29/11/2021

New Liverpool Primary School (SSD-10391)

Request for additional information

**SWEPT PATH ASSESSMENT**

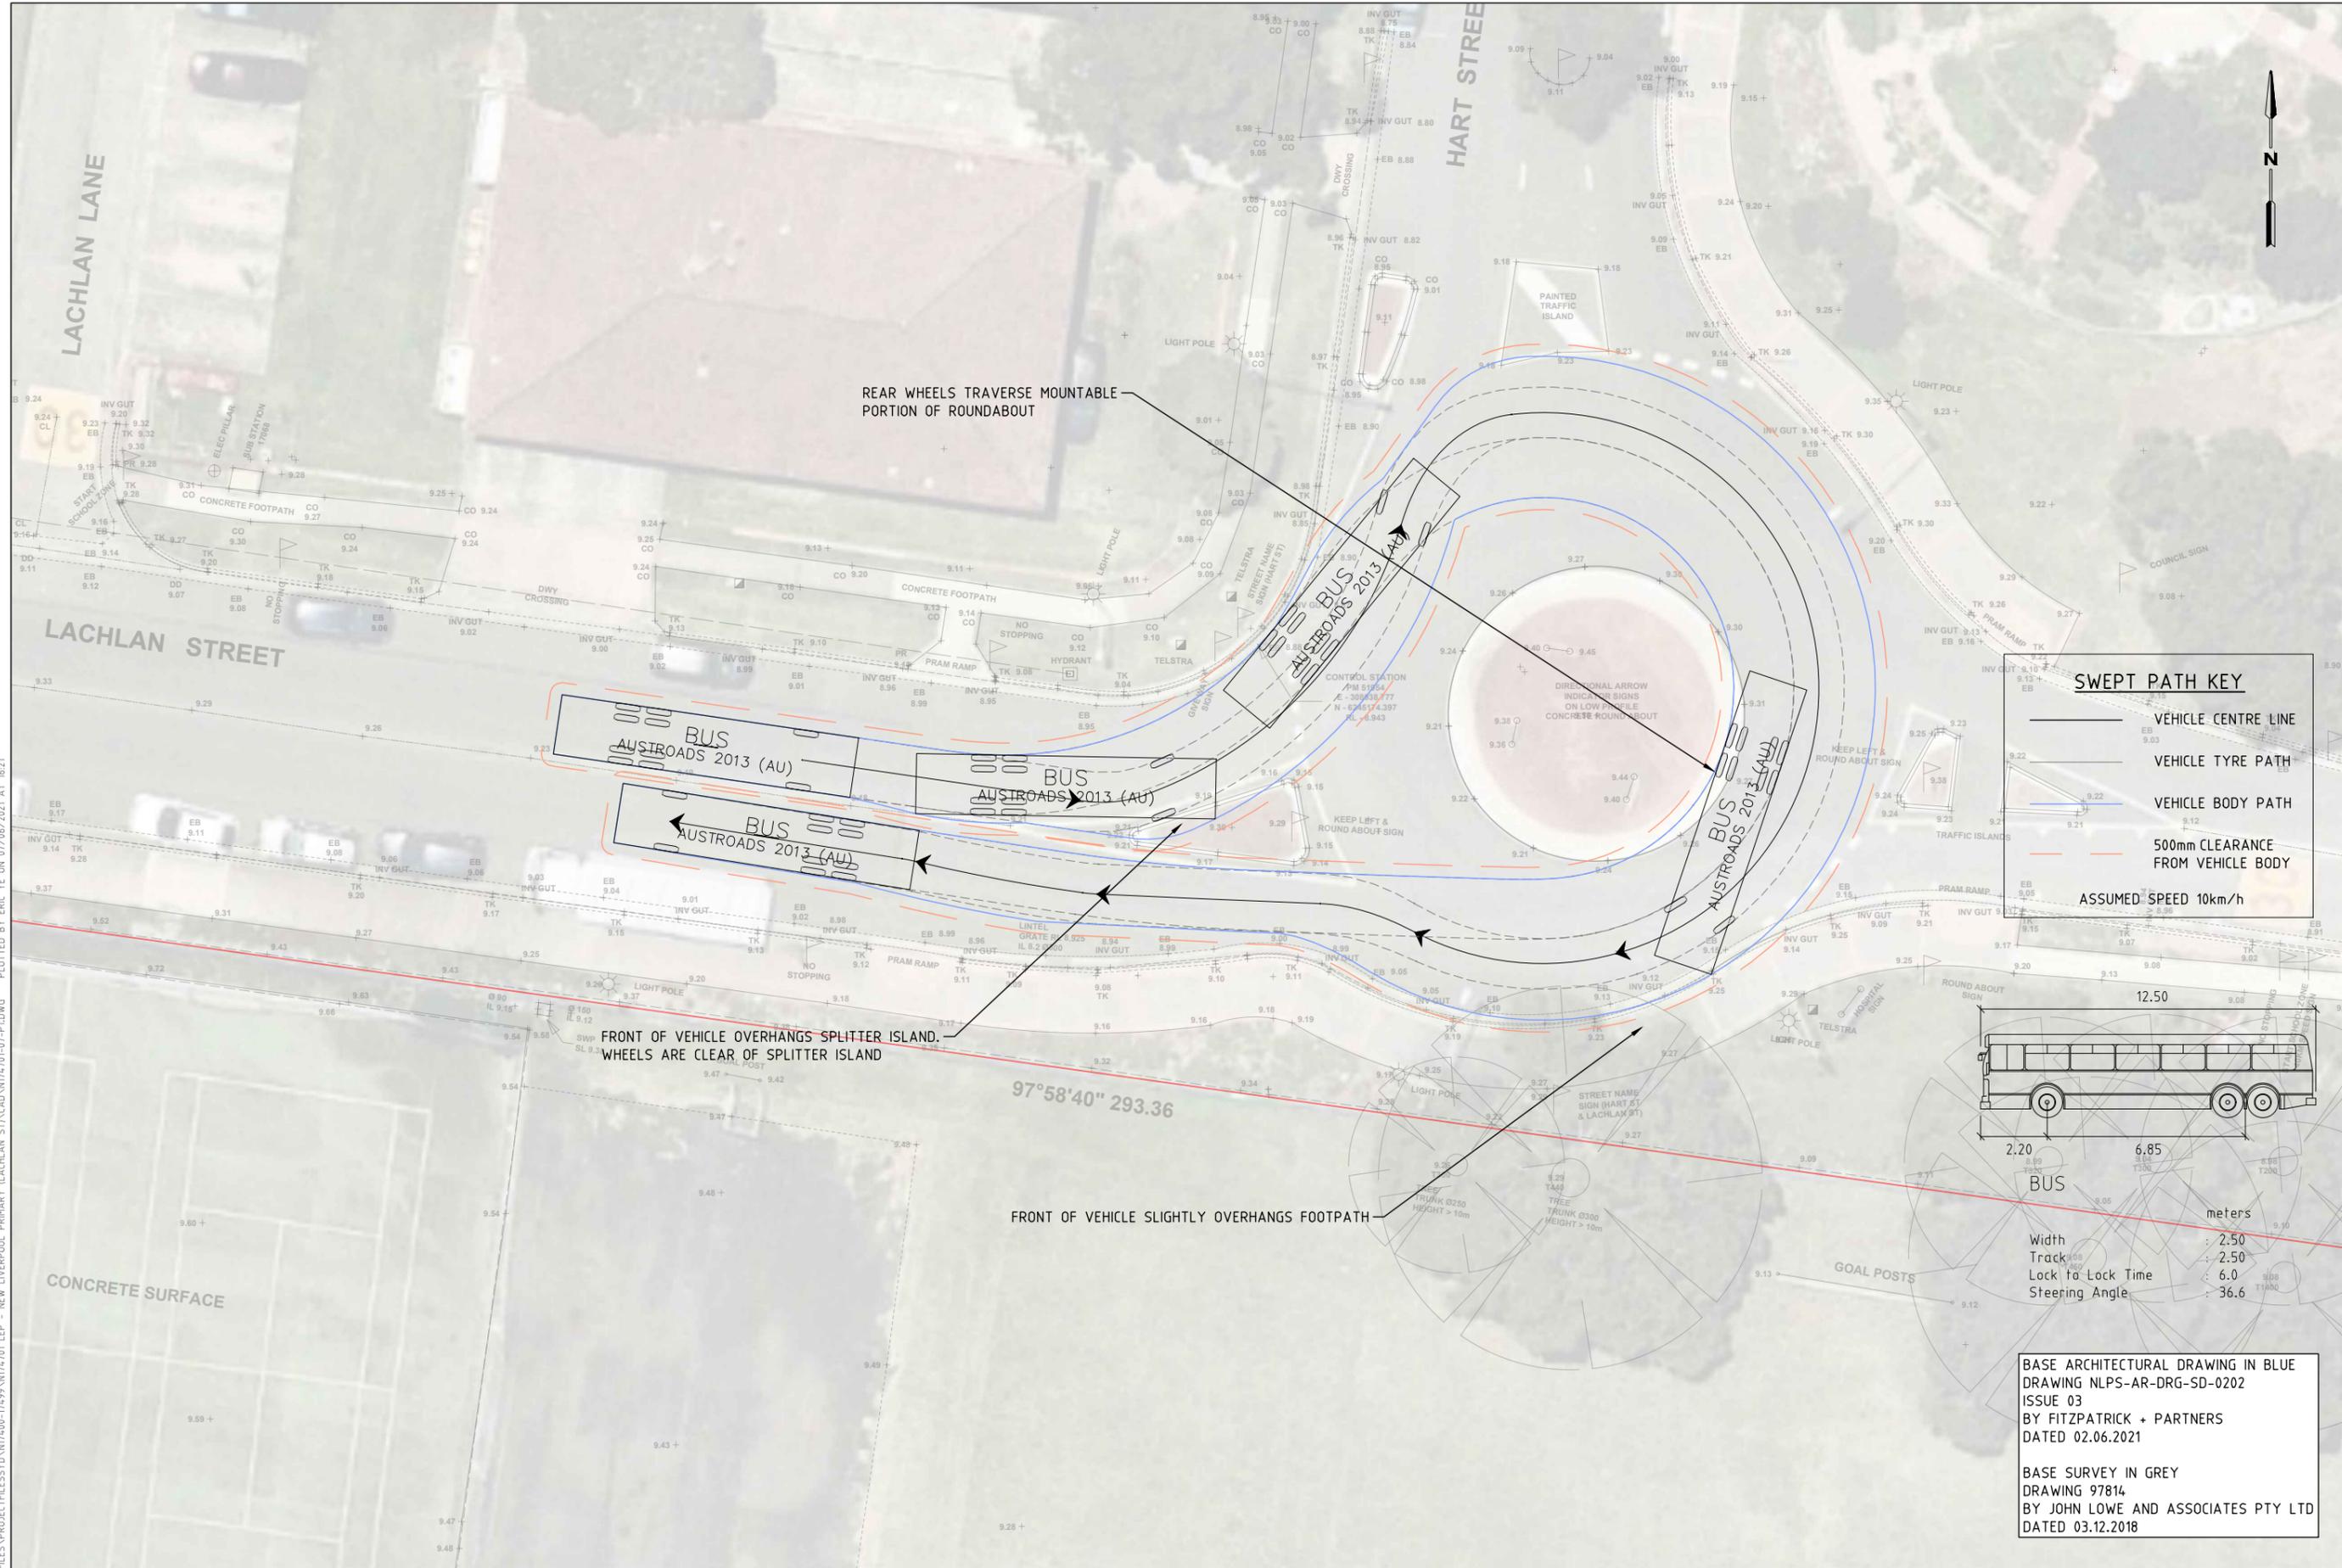
6. The Waste Hardstand Site Plan (Appendix K) includes details of a medium rigid vehicle (MRV) turning circle, which would access the site for waste collection in the future. However, the Department notes that the allocated hardstand space is not sufficient for MRV manoeuvring and that the MRV would encroach into the bike rack area and the ELC play area. Please address this issue and relocate/resize the hardstand area or relocate the vehicle turning circle area to allow for adequate manoeuvring of MRV within the site.
